Traffic Memo

The project involves a 40.1 acre site divided into four (4) lots located along Cutis Road in eastern El Paso County. The project area is zoned for Residential usage which will have minimal traffic trips generated. The estimated trips per day for each lot will be under 100. Per Section B.1.2.B.1.2 of the ECM, a traffic impact study is not required based on the following criteria:

# ROADWAY PLANS WYOMING ESTATES SUBDIVISION EL PASO COUNTY, CO

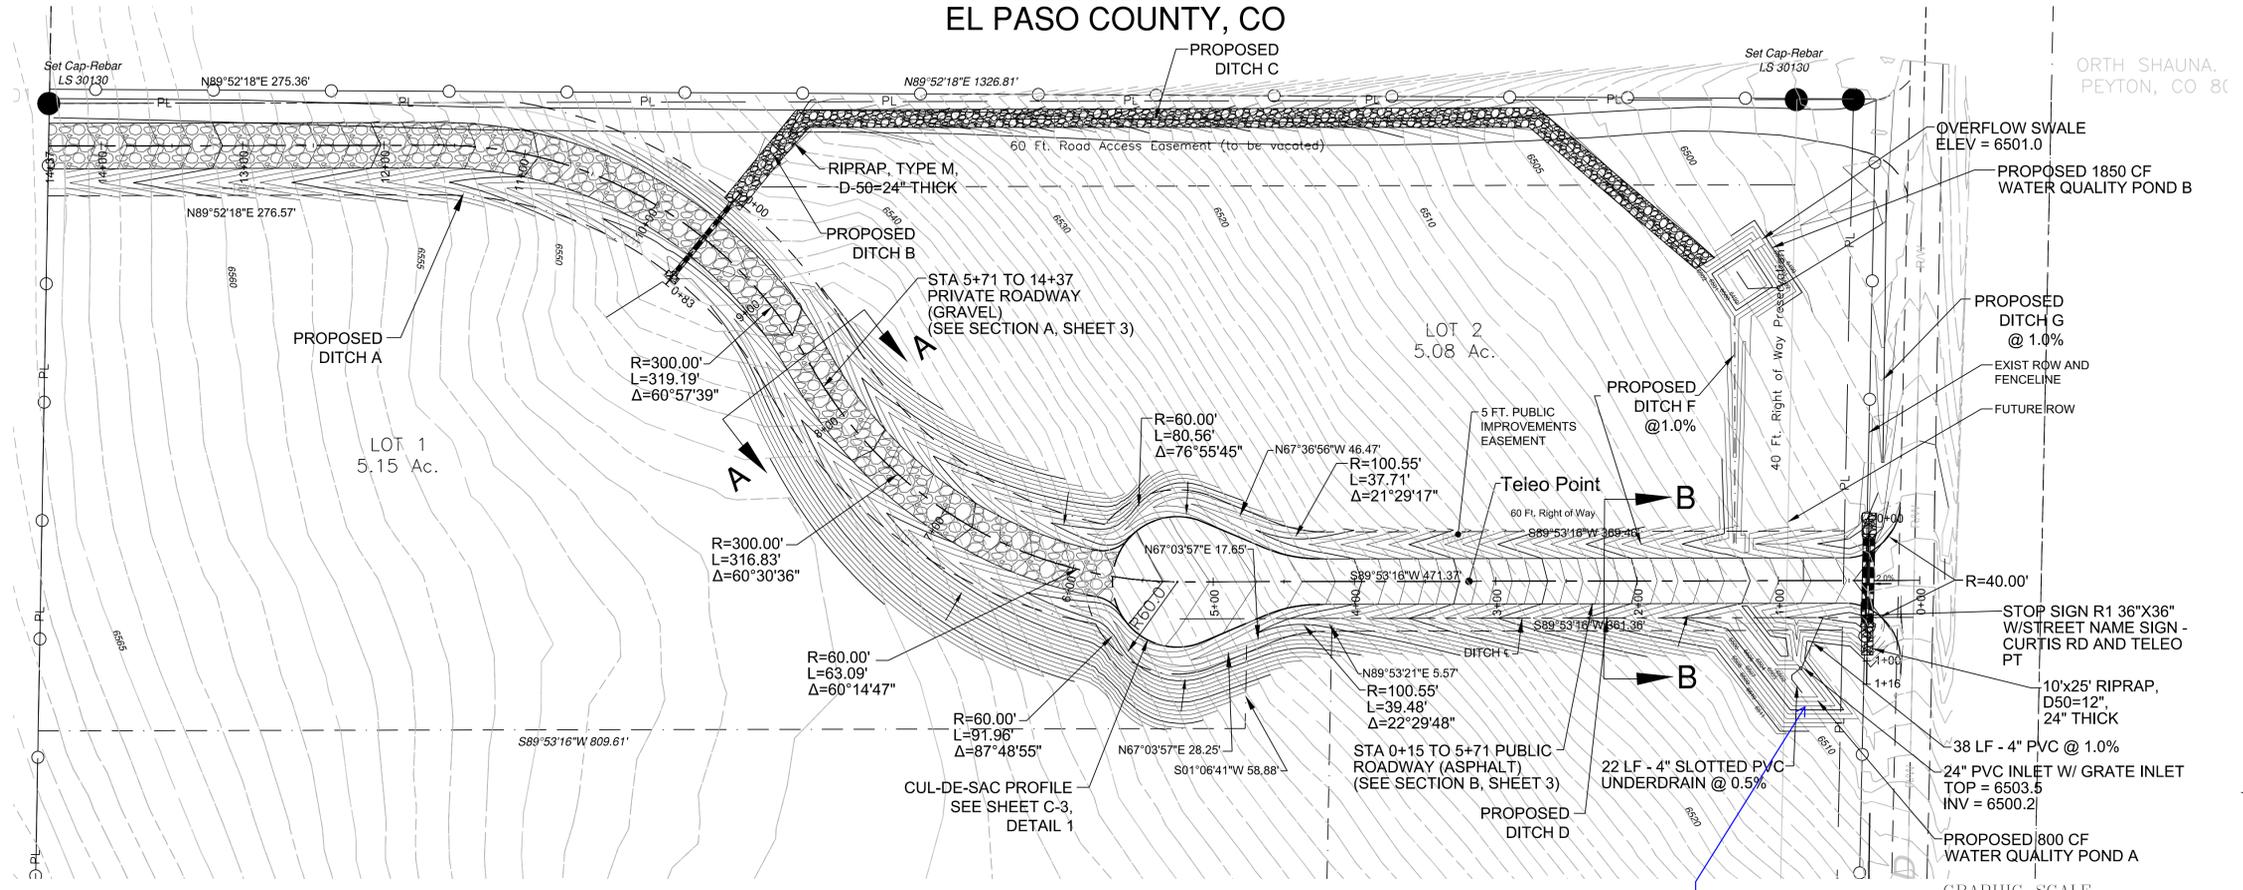
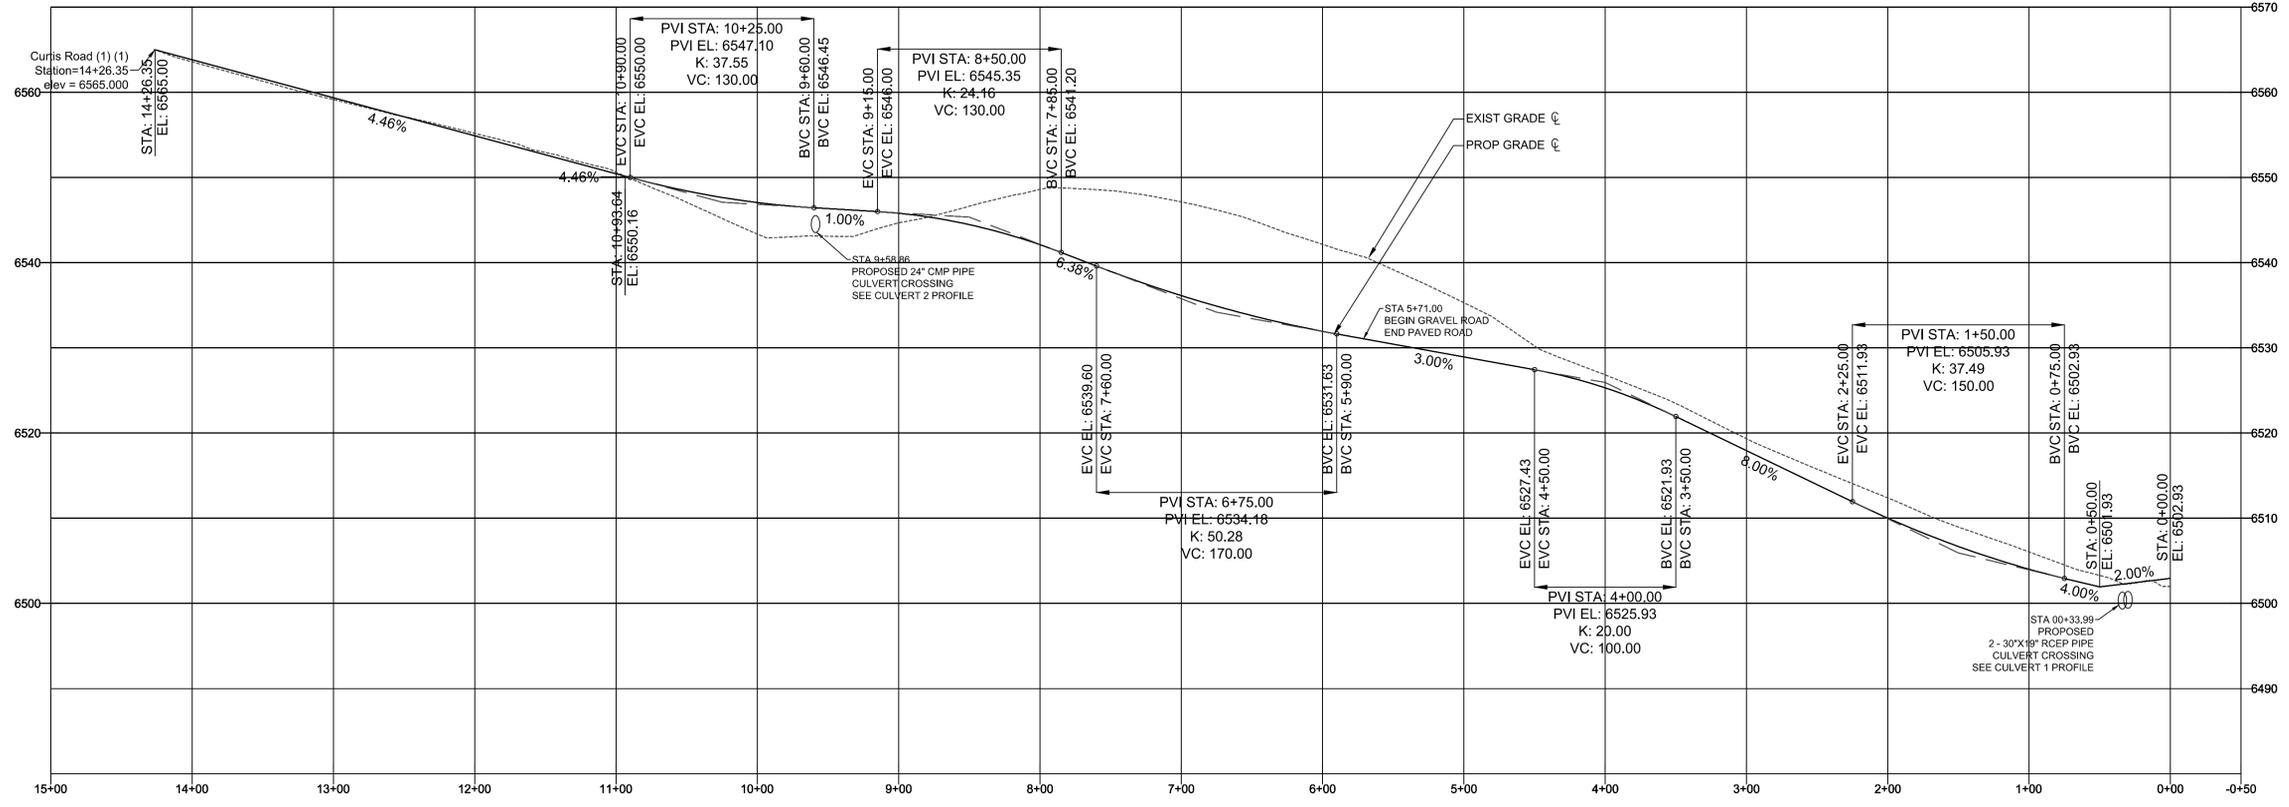
Review 2 comment: A minor roadway (local roadway) is being proposed therefore this criteria has not been met. Per criteria a traffic memo by a licensed engineer would be required.

Review 3: Unresolved. please submit a traffic memo by a licensed engineer as criteria for not providing a TIS has not been met due to the proposed roadway.
